20 April 2018

**Goulburn Mulwaree Council Preliminary Comments
Goulburn Base Hospital Redevelopment
130 Goldsmith Street, Goulburn (Your Ref: SSD 8667)**

Goulburn Base Hospital Redevelopment

Client	NSW HEALTH INFRASTRUCTURE
Project	GOLDBURN HOSPITAL & HOSPITAL SERVICES REDEVELOPMENT
Title	HYDRAULIC SITE LAYOUT - OVERALL
Original Size	A1
Drawing No.	22-18102-H101
Rev.	A

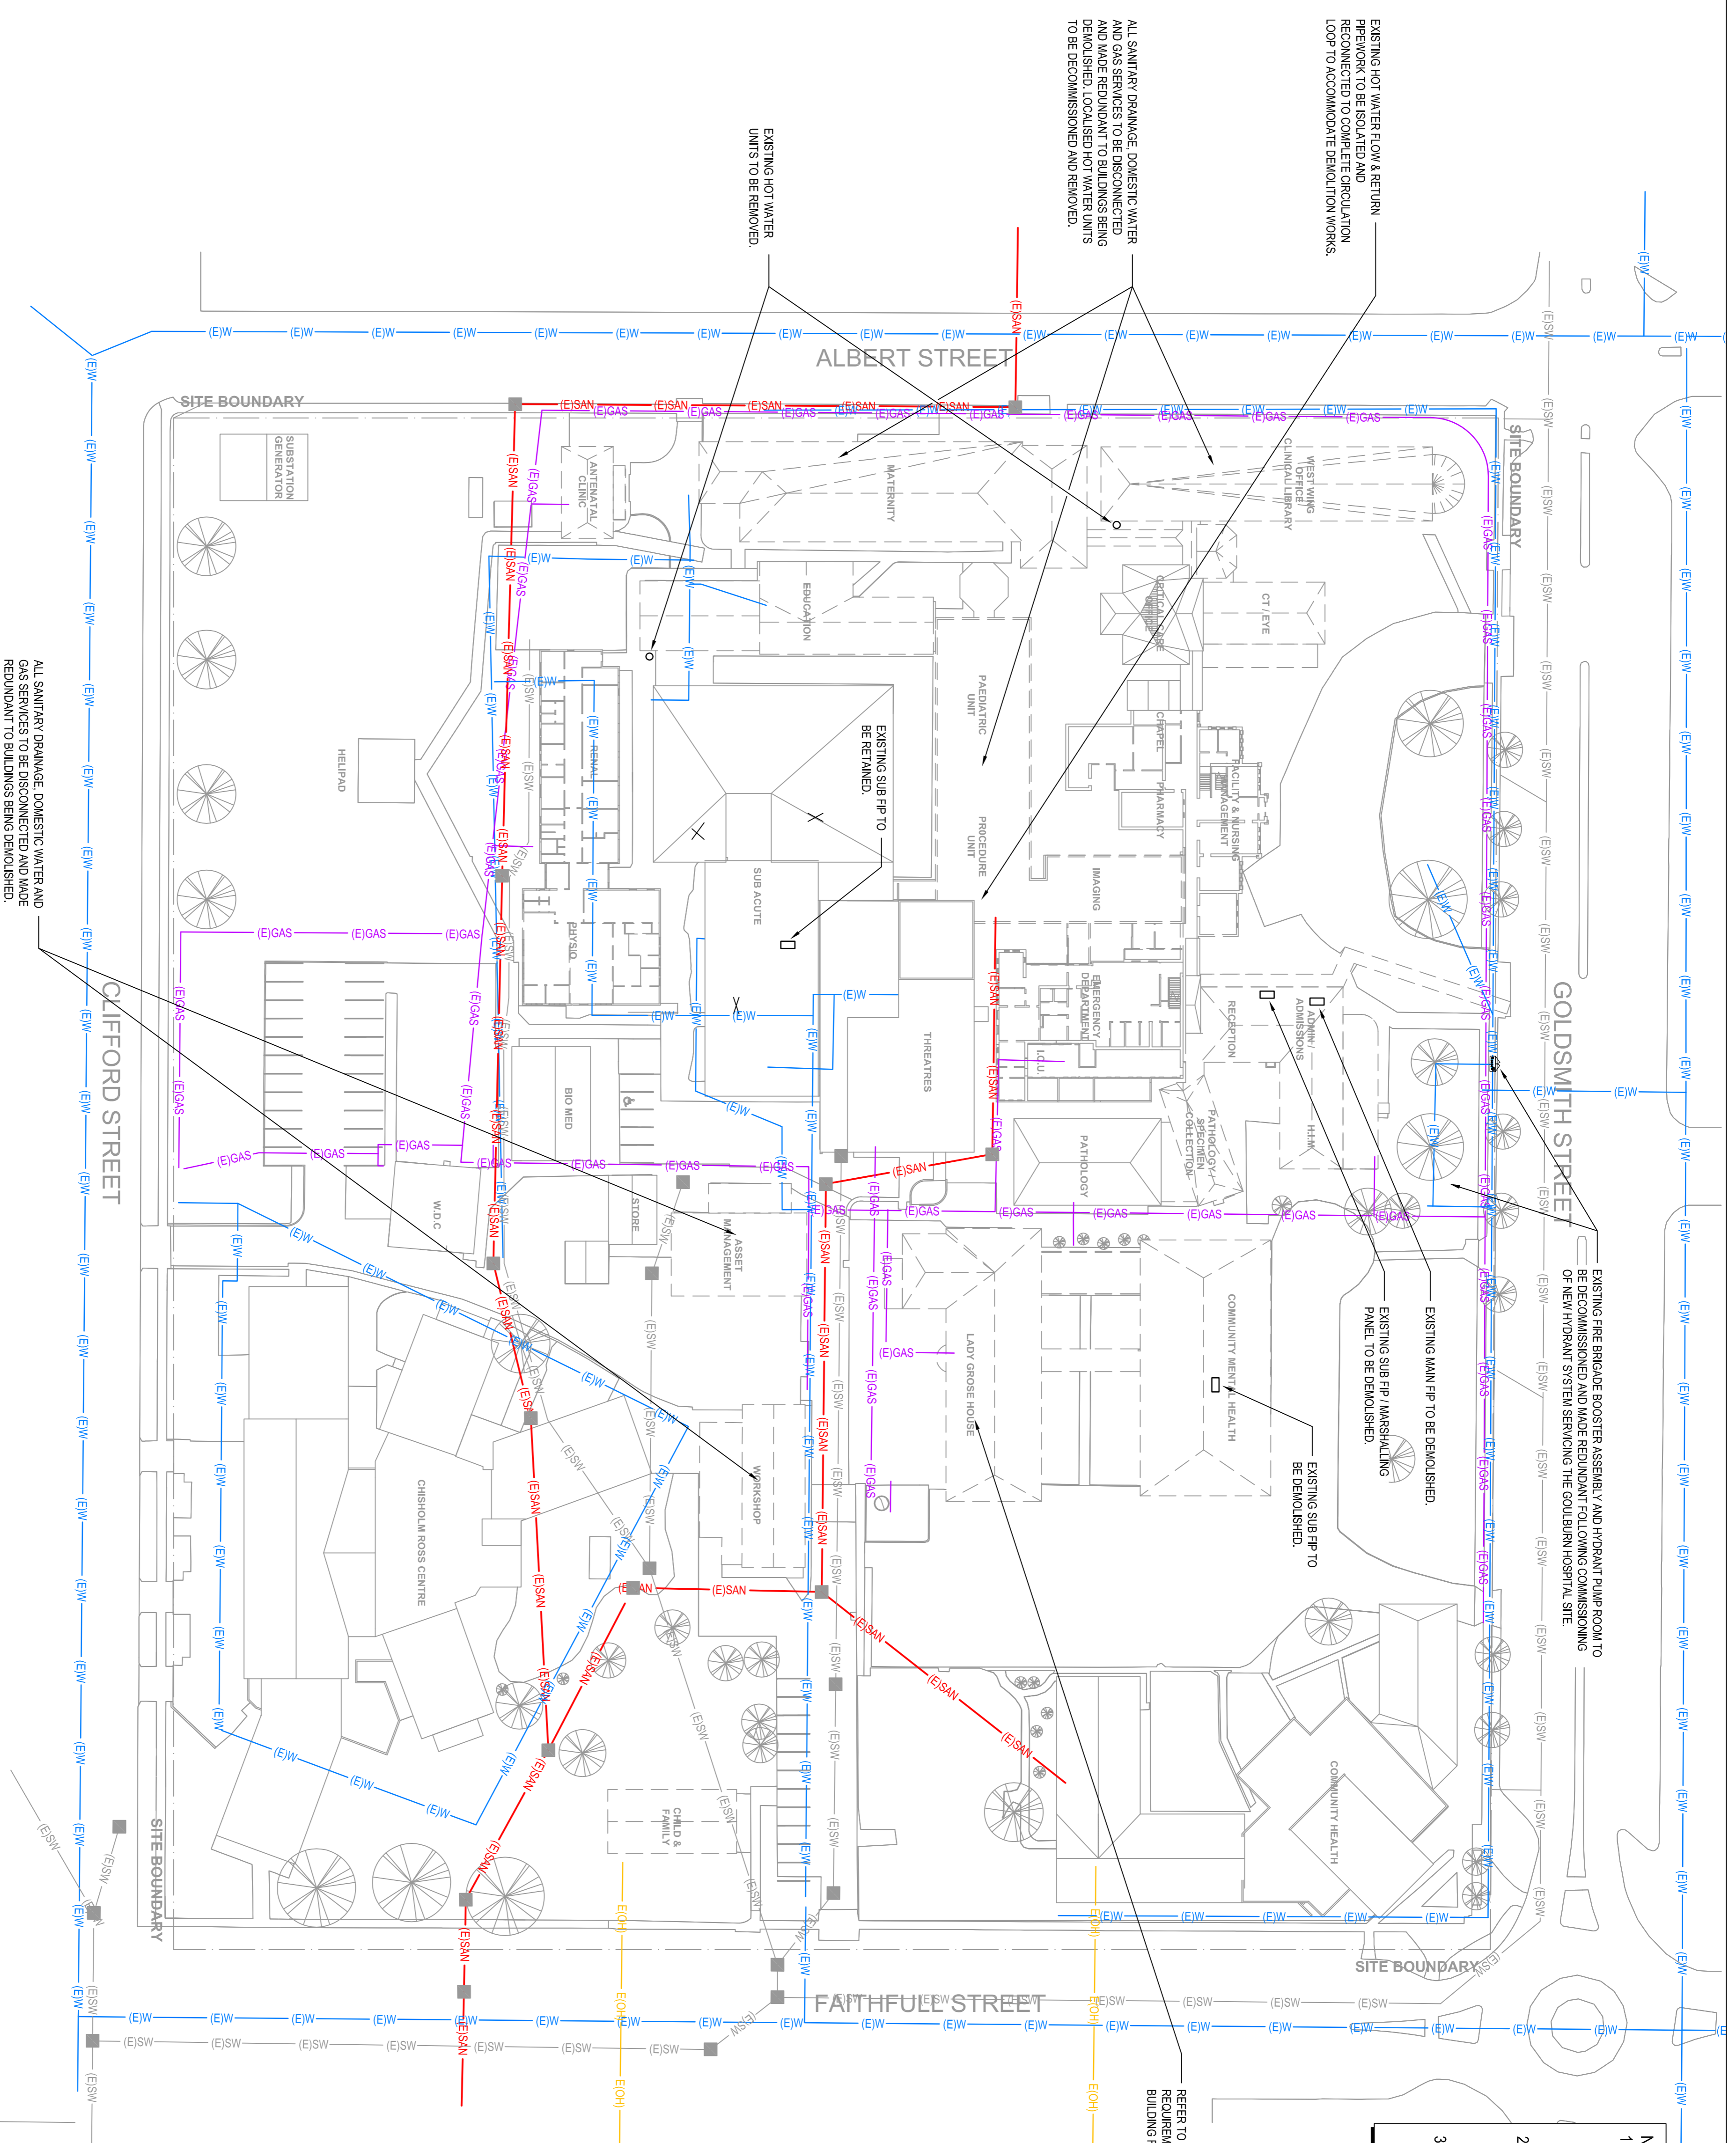
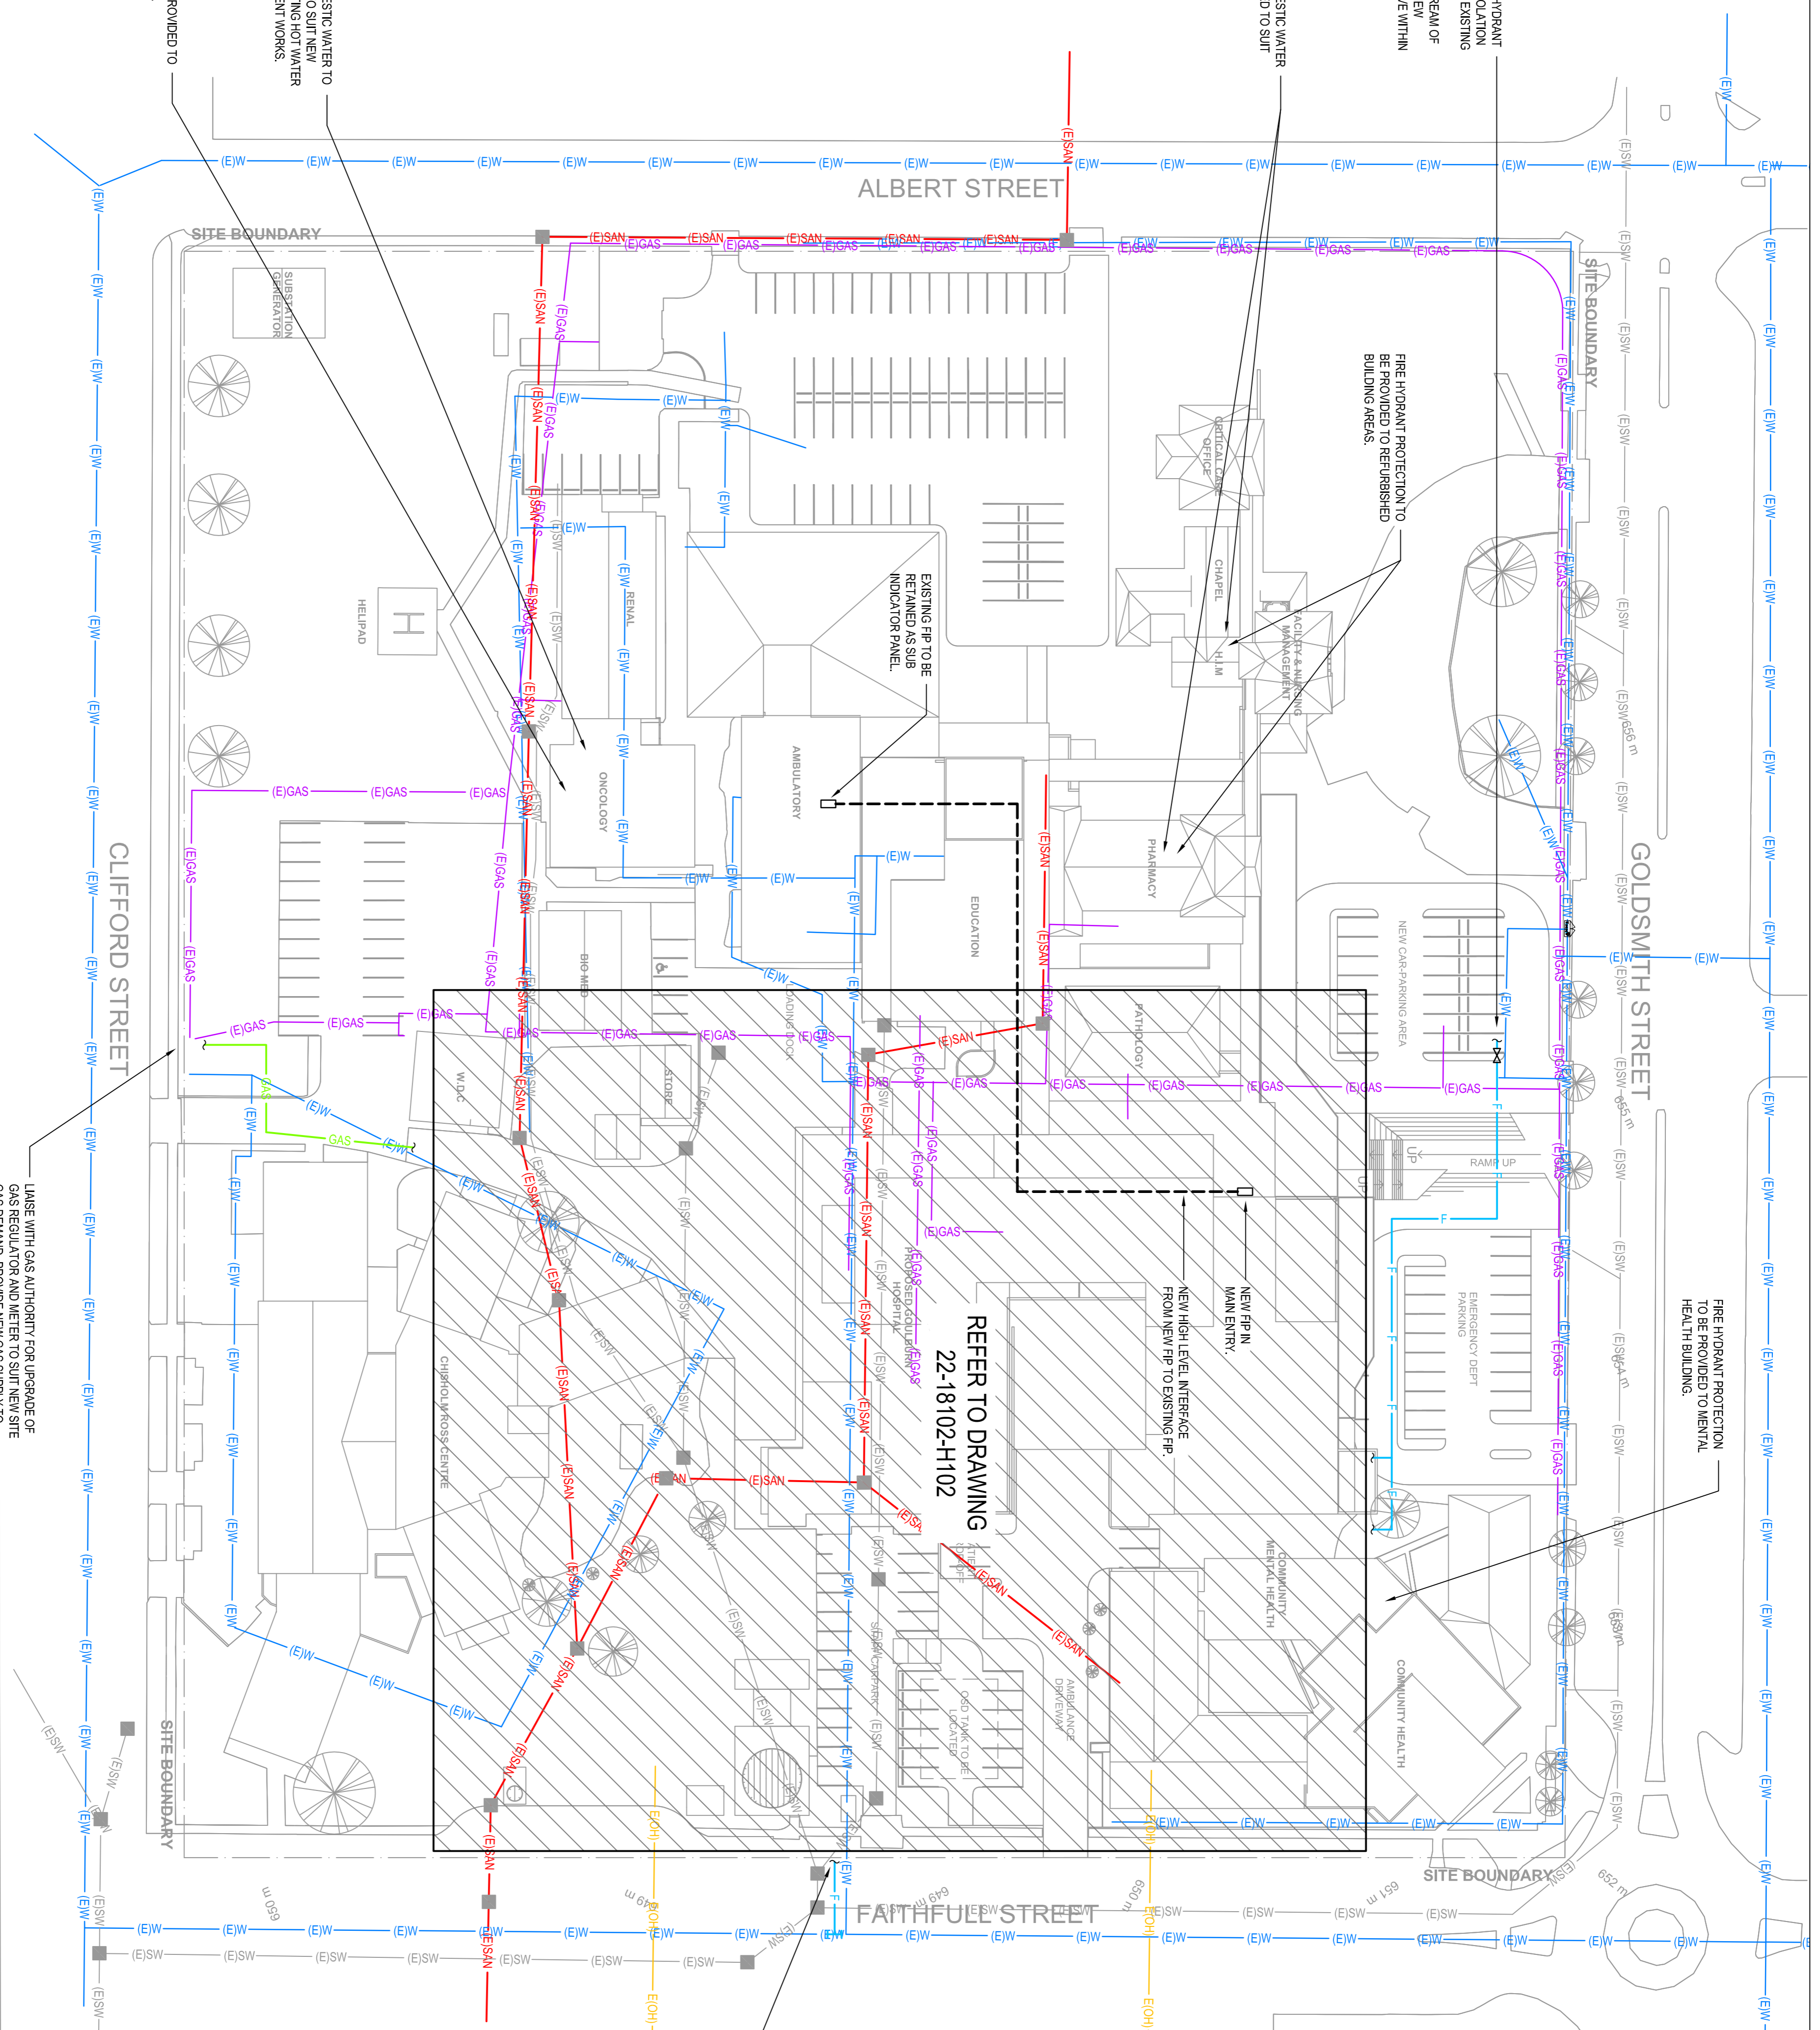
Document	Preliminary Comments
Appendix 14b – Hydraulic Services Plans	<p>Refer to Drawings H100, H101 and H102. Council will provide a quotation upon receiving an application for the following:</p> <ul style="list-style-type: none"> ▪ Disconnect & cap the existing 150mm fire service in Goldsmith St following commissioning of the new dedicated fire service off Faithful St. ▪ Install a new 150mm dedicated fire service from council's water mains to the property boundary in Faithful St, ready for downstream extension & installation of DCV with detector check meter by others
Appendix 15 – Landscape Plans – Part 1 - 5	<ul style="list-style-type: none"> ▪ The plans are professionally prepared and the analysis section is generally well considered. ▪ Page 104 mentions that there are areas of vegetation in the Goulburn region that contain River Red Gums. This is not the case. The relevant species found with Yellow Box is likely to be Blakely's Red Gum e.g. Eucalyptus blakelyi. River Red Gums are not sufficiently frost hardy to survive locally. ▪ The original hospital buildings are heritage listed and have a formal symmetrical layout albeit that asymmetric, unsympathetic additions have been added over the years. The proposed landscape design doesn't respect the formality of the original hospital. ▪ Arcadia plan page 120 > Detail Plan – Old Entry. ▪ The area in the immediate vicinity of the Goldsmith St frontage of the original Manfred designed buildings and including the crescent shaped driveway should be handled in a more formal way. This can then morph into the informal sensory garden proposed in the Northwest corner of Goldsmith and Albert Streets. The design is relevant to the area generally but not necessarily the hospital site specifically. ▪ There should be no planting directly against the historic buildings as this will have a negative impact on the buildings footings via increased water movement. A space of approx. 2.0m should be left with a suitable gravel surface layer. ▪ As noted below the existing Phoenix canariensis, Canary Island Date Palm should either be retained in situ or transplanted to a location as close as possible to its existing position for example in the proposed entry to the new building. ▪ Arcadia plan page 119 > Detail Plan – Main Pedestrian Entry. ▪ There is insufficient planted area to reduce the visual impact of the new buildings and expansive paved parking areas proposed. Additionally more shade trees should be used. This is particularly so for the uphill/western side of the entry 01 and the parking area off Albert Street. <p>Forwarded the Landscape Design Report to Louise Thom regarding the suitability of the informal design adjacent to the original heritage buildings</p> <p>The plan proposes the removal of the Eastern Wing of the original Manfred design. This is a significant impact on the fabric of the site. (See attached)</p>
